Broadland District Council Response to Examining Authority's Written Questions (ExQ1)

Deadline 1 (6th July 2021)

HE551490-GTY-ELS-000-DR-LX-30001

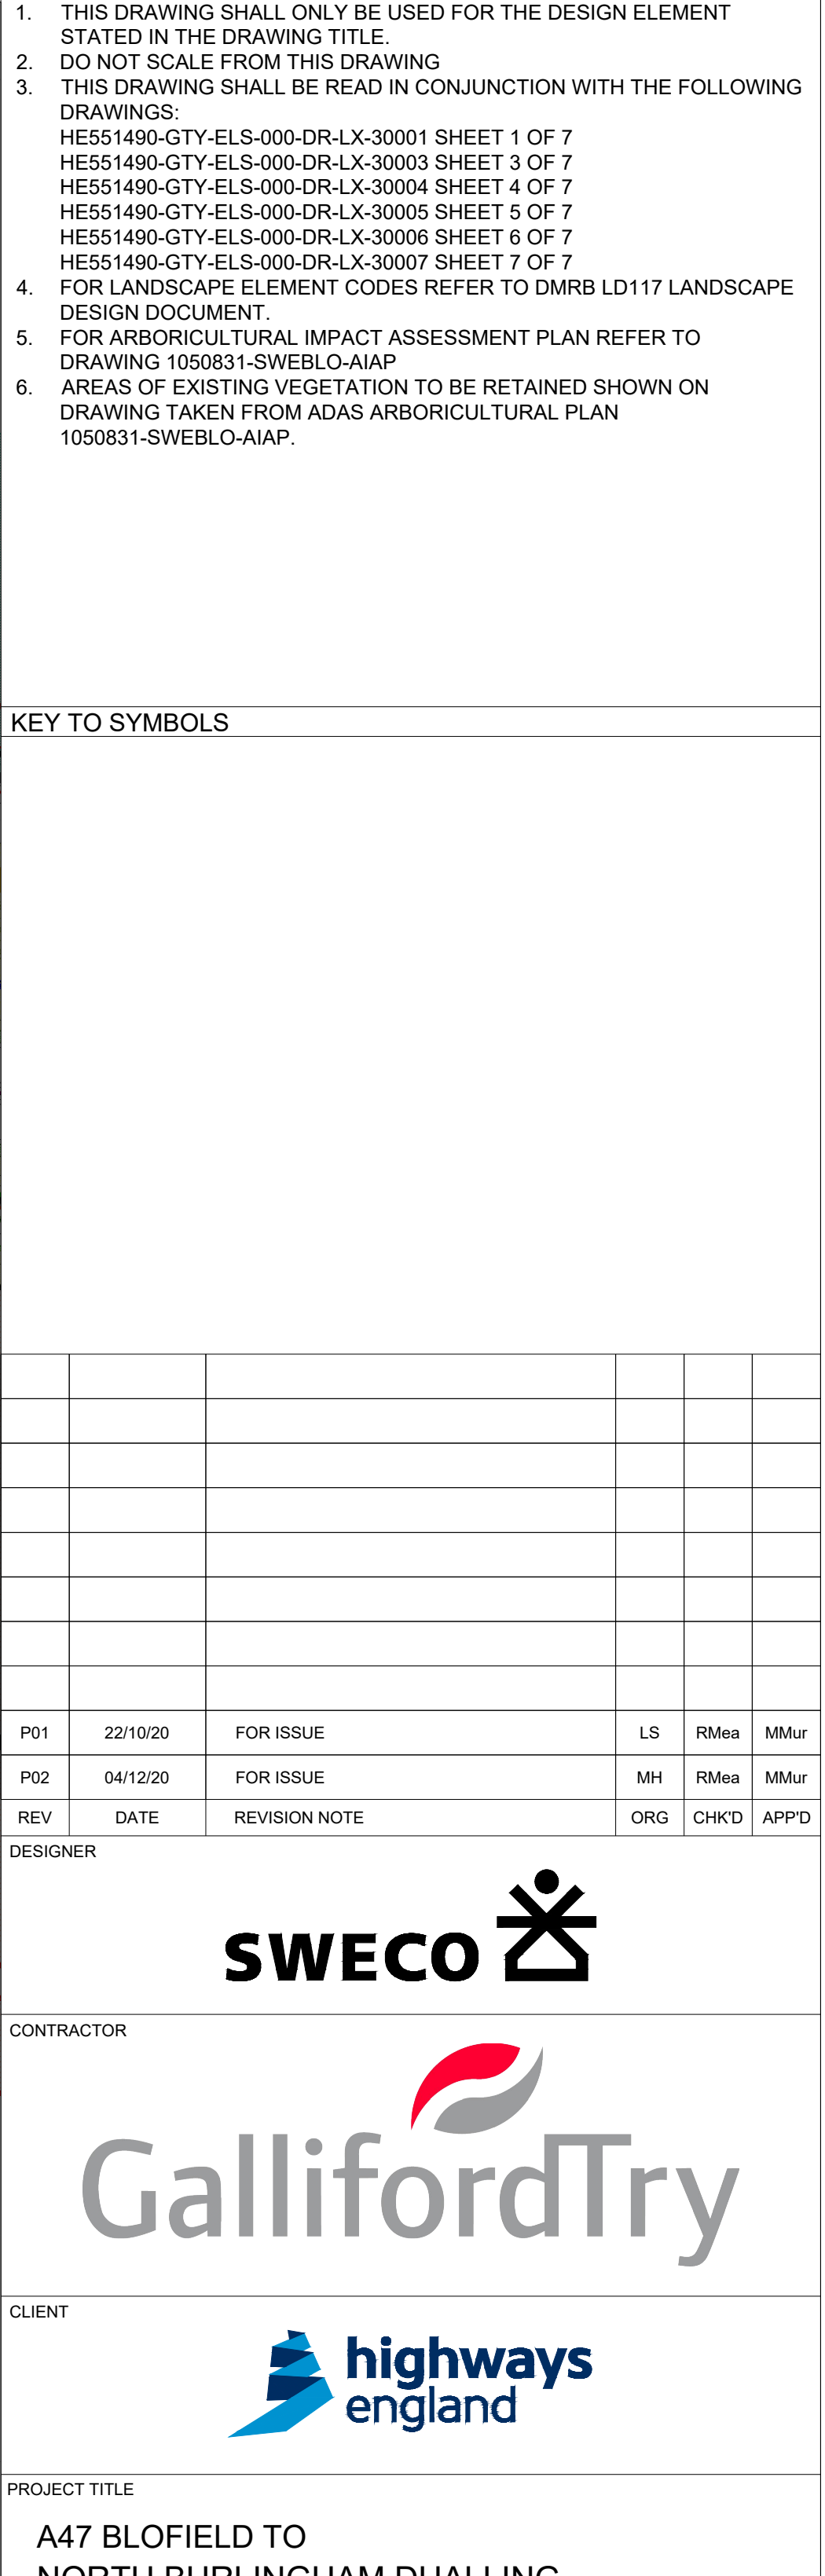
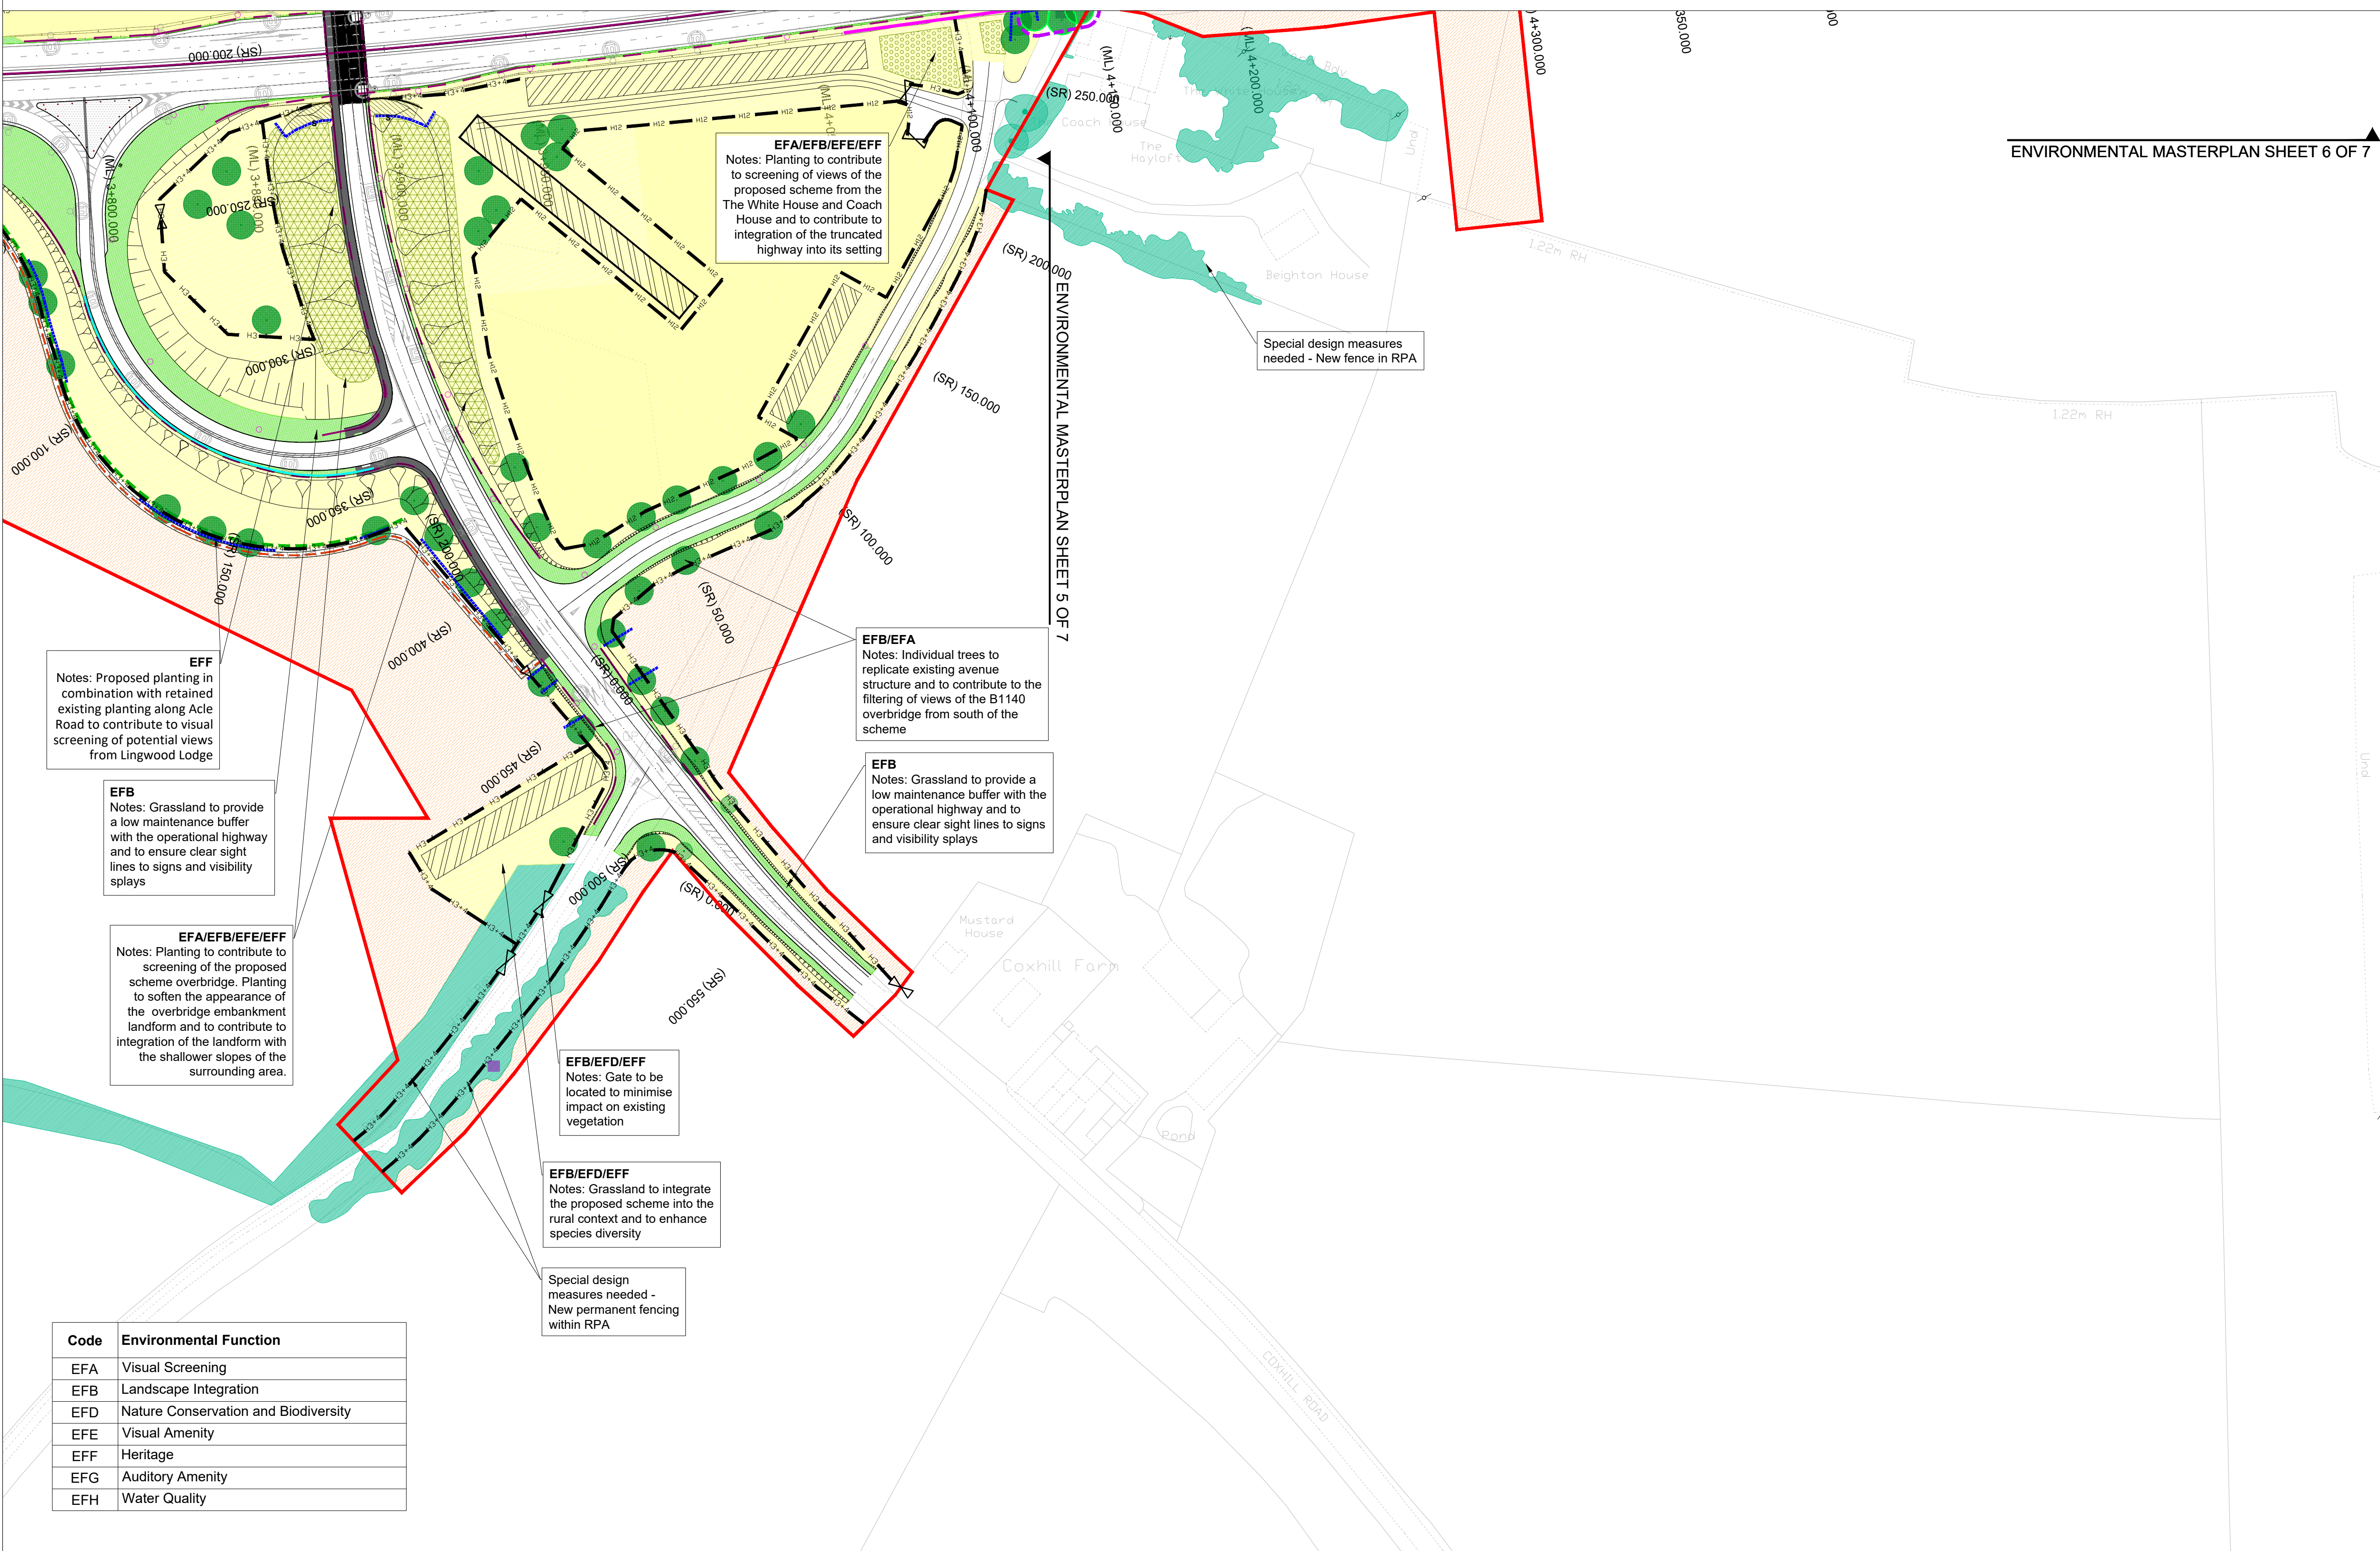
1.10.2	Is BDC and NCC satisfied with the Masterplan [APP-118] and the proposed species mix as shown on the final page of the Masterplan?	BDC have no reasons to dispute the spatial arrangement and general design of the planting proposals.

BDC would query the use of ivy (<i>Hedera helix</i>) and Blackberry (<i>Rubus fruticosus</i>); these are potentially quite dominating of young woody planting, and can be problematic in mature hedgerows and plantings. Whilst there is no disputing the important habitat and food sources these species can provide, it might be that they are best introduced as part of management, rather within the initial mix.
